SPR EA1N and EA2 PROJECTS

DEADLINE 12 – COMMENTS ON THE APPLICANTS DEADLINE 11 SUBMISSIONS IN RESPECT OF ISH 16, ISH 17, SUBSTATIONS DESIGN, LANDSCAPE AND HERITAGE GIS ADDENDA

Interested Party: SASES PINS Refs: 20024106 & 20024110

Date: 28 June 2021 Issue: 1

## **Figure 29.37**

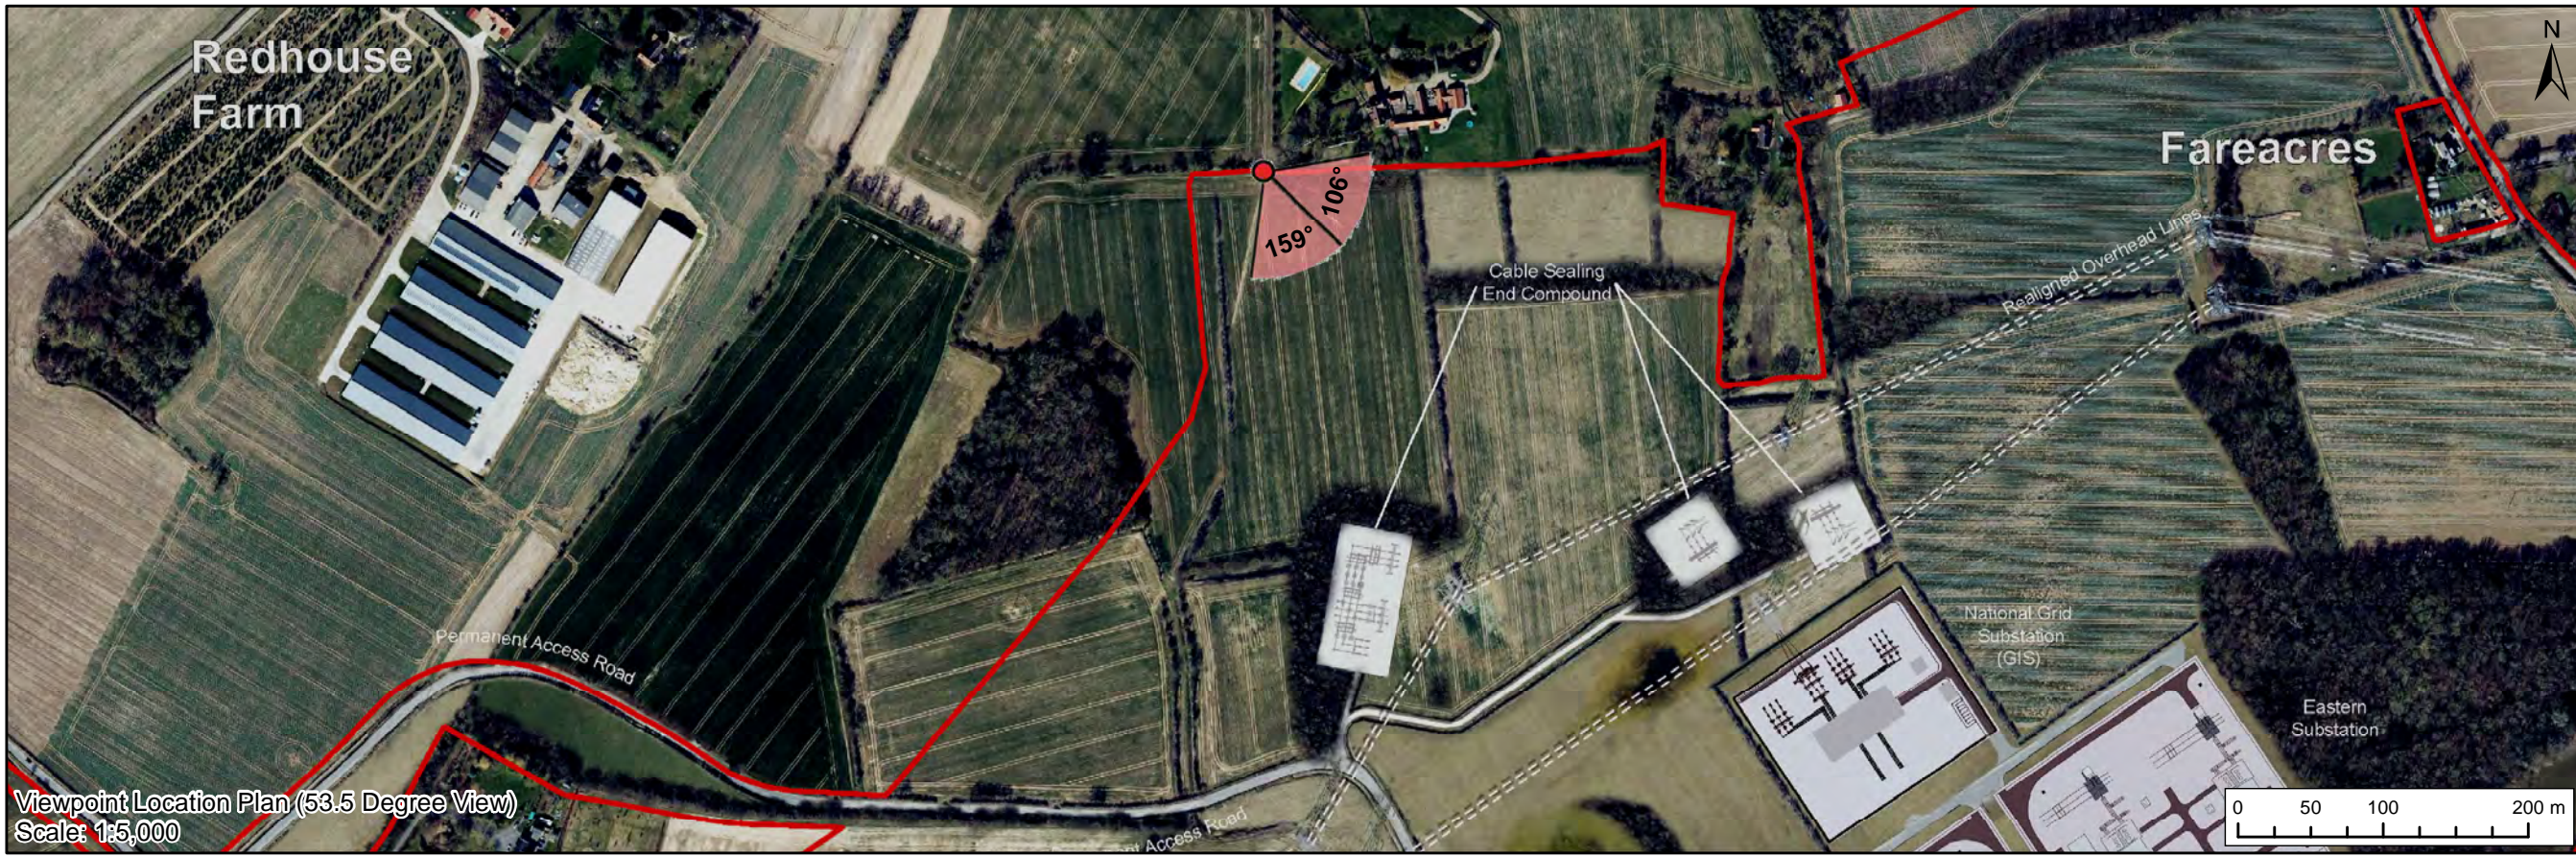
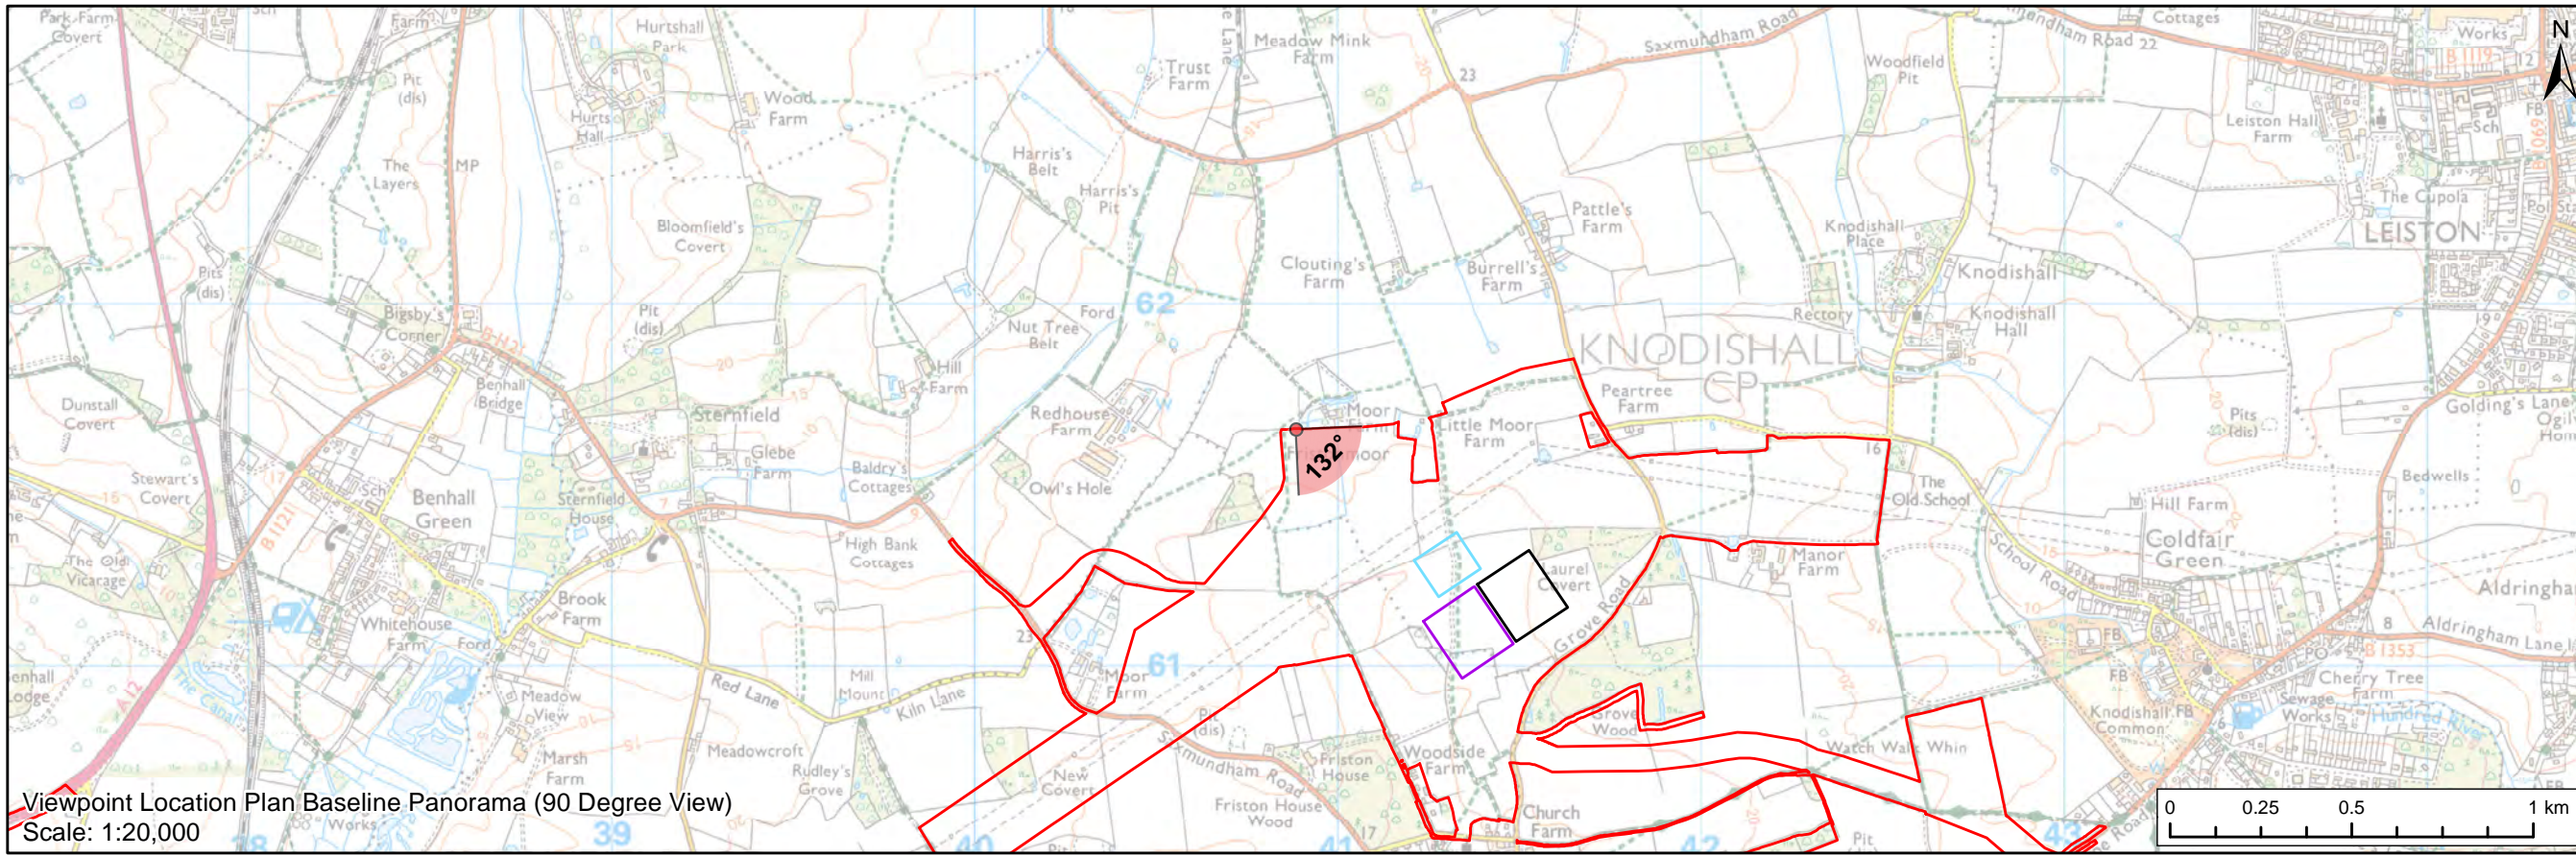
6. From **Vp 5** the AIS option is visually more intrusive. However, it is the largest sealing end compound and the introduction of an additional pylon, significantly closer to the viewpoint than any of the existing pylons, that are the most intrusive element in these views and these sit to the west of the gap that would be created. This intrusiveness is particularly harmful from Vp 5 because the pylon and the sealing end compound are directly in front of the view towards Friston church. It is this particular arrangement that is most harmful to the visual amenity from Vp 5, the visual amenity of the residents of High House Farm and the setting of the historic farmhouse (see evidence of Dr Richard Hoggett).

7. The visualisations from Vp 5 are not fully representative of the visual harm as they do not include several components that would be present. The omissions area set out in *SASES REP11-177 Comments on the drawings in the design and layout of the substation's submission in response to Rule 17QE Issued on 13 May 2021*. For ease of reference the omissions listed are:

**Figure: 29.37f**  
**Viewpoint 5: Public Right of Way, near Moor Farm**

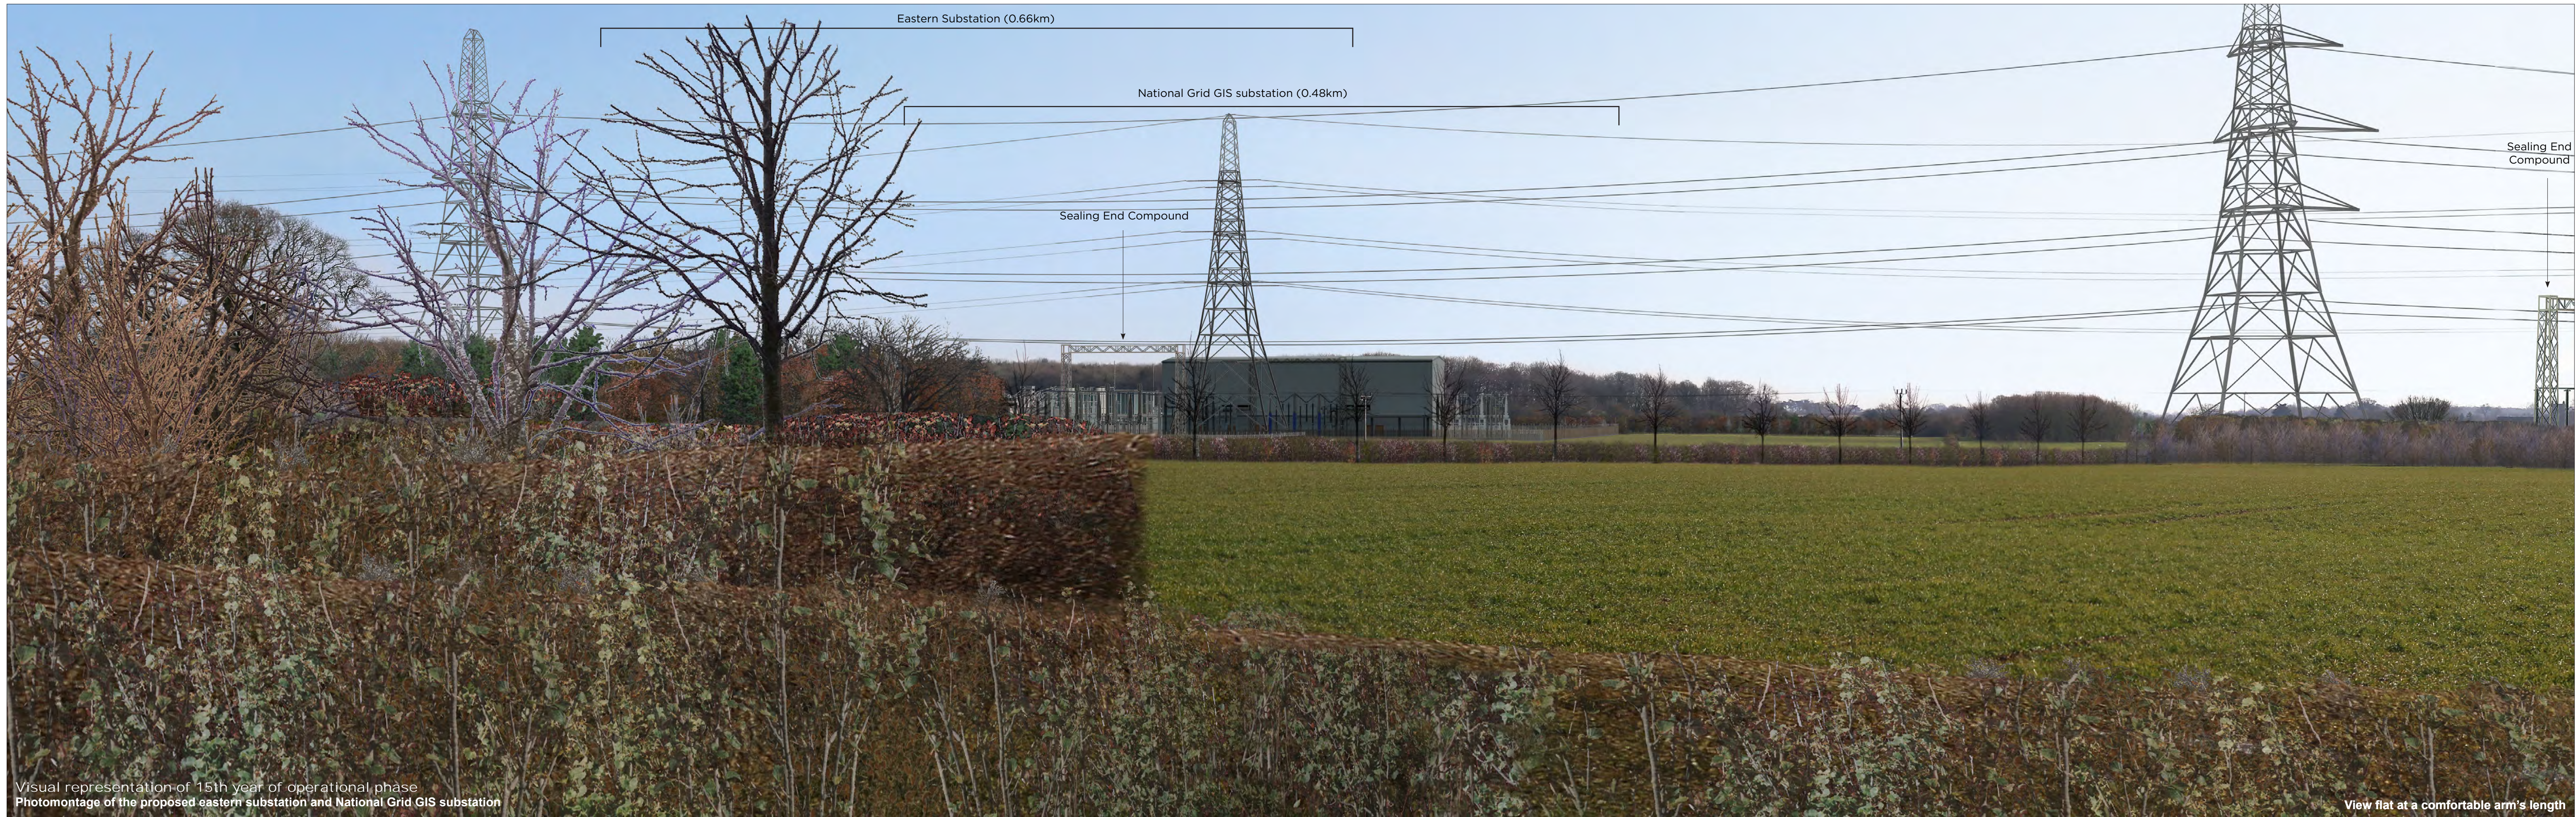
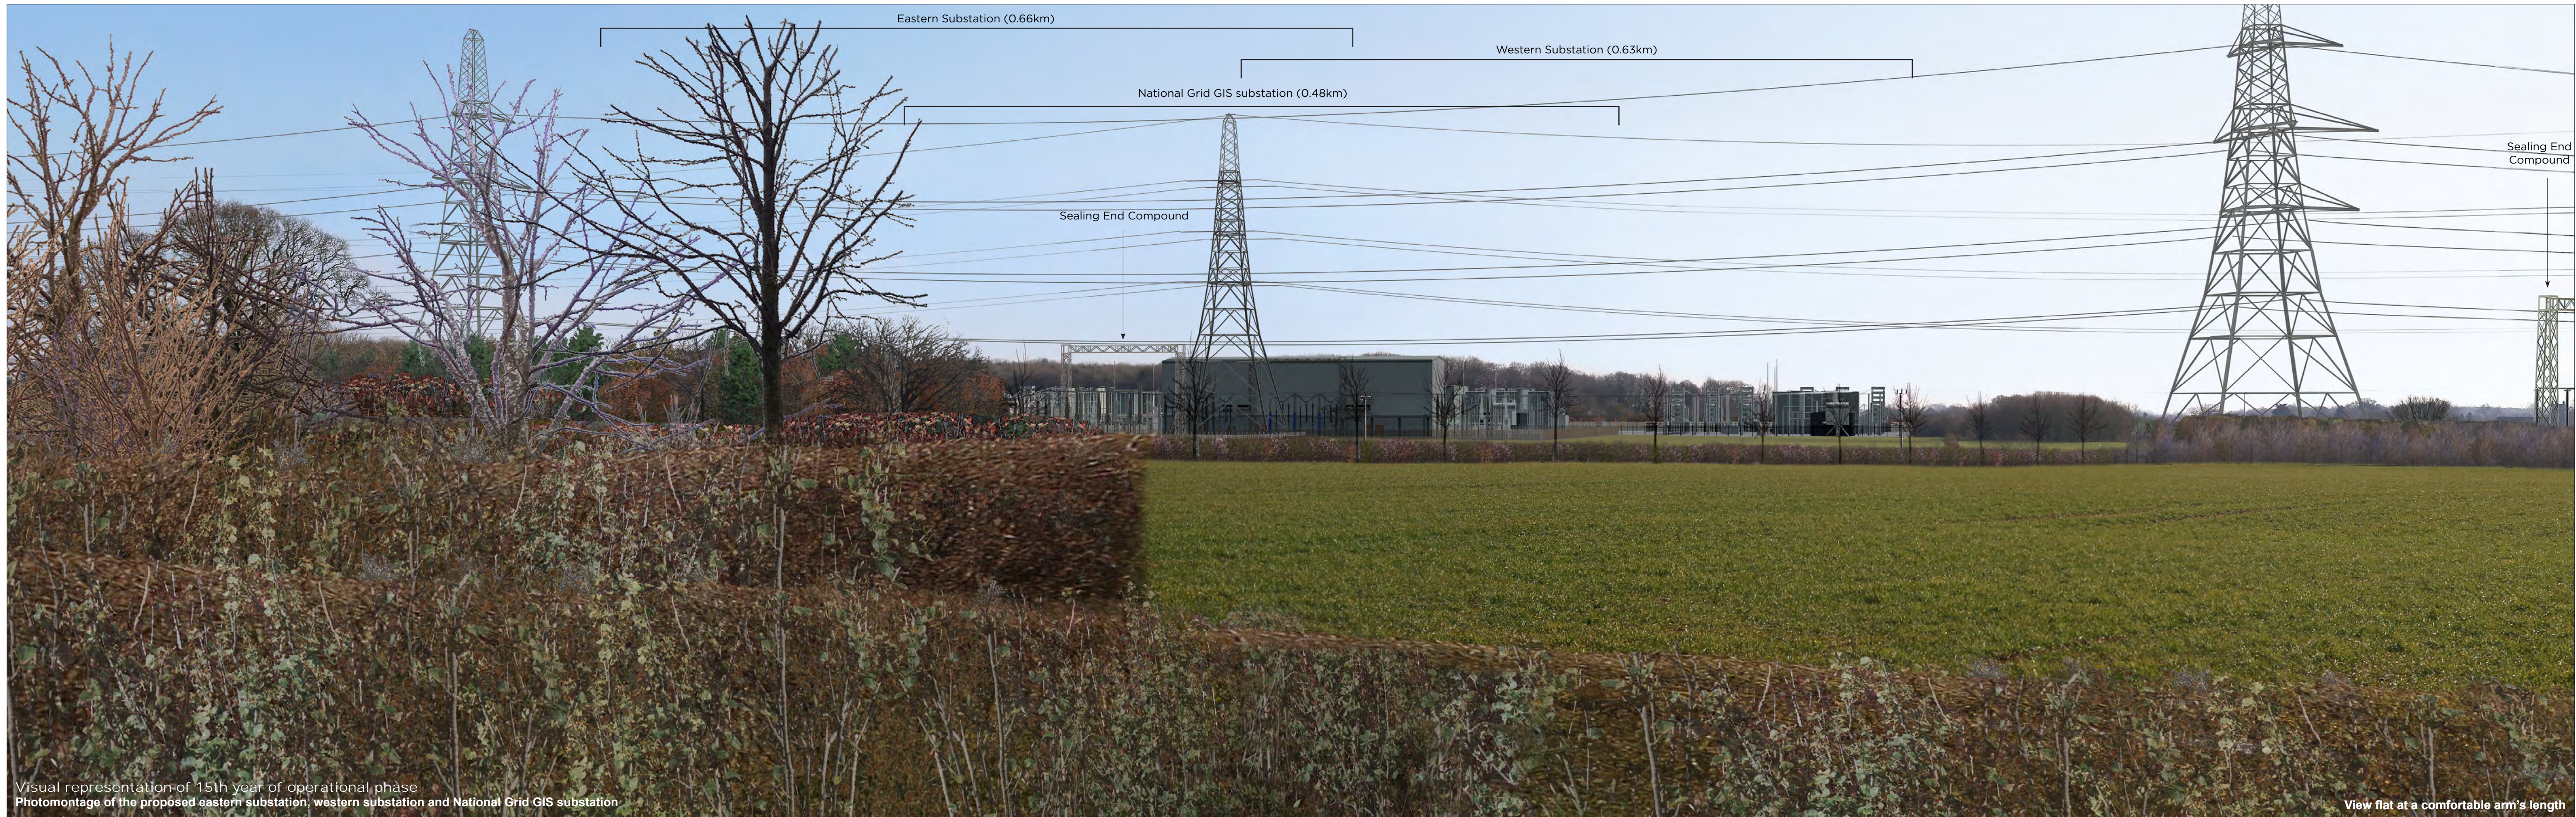
- The OHLs end on the right-hand pylon, when in fact they continue on;
 - The quad core OHLs are shown as thin cables;
 - The cables are inaccurately positioned on the tension pylon, they should be much higher;

- None of the OHL insulators are shown (they will be especially prominent on the tension pylon by the western most sealing end); and
 - The many cables and insulators and hardware from the sealing ends and gantries up to the OHL are not shown.

8. The GIS option would be visually less intrusive from Vp 5 especially if only one SPR substation was constructed which, as previously indicated would be on the site of the eastern substation. However, no planting mitigation, or

other mitigation such as relinquishing of the land freed up is proposed should the GIS option be chosen, or only a single SPR substation constructed. Consequently, few of the potential benefits of these options would be realised.
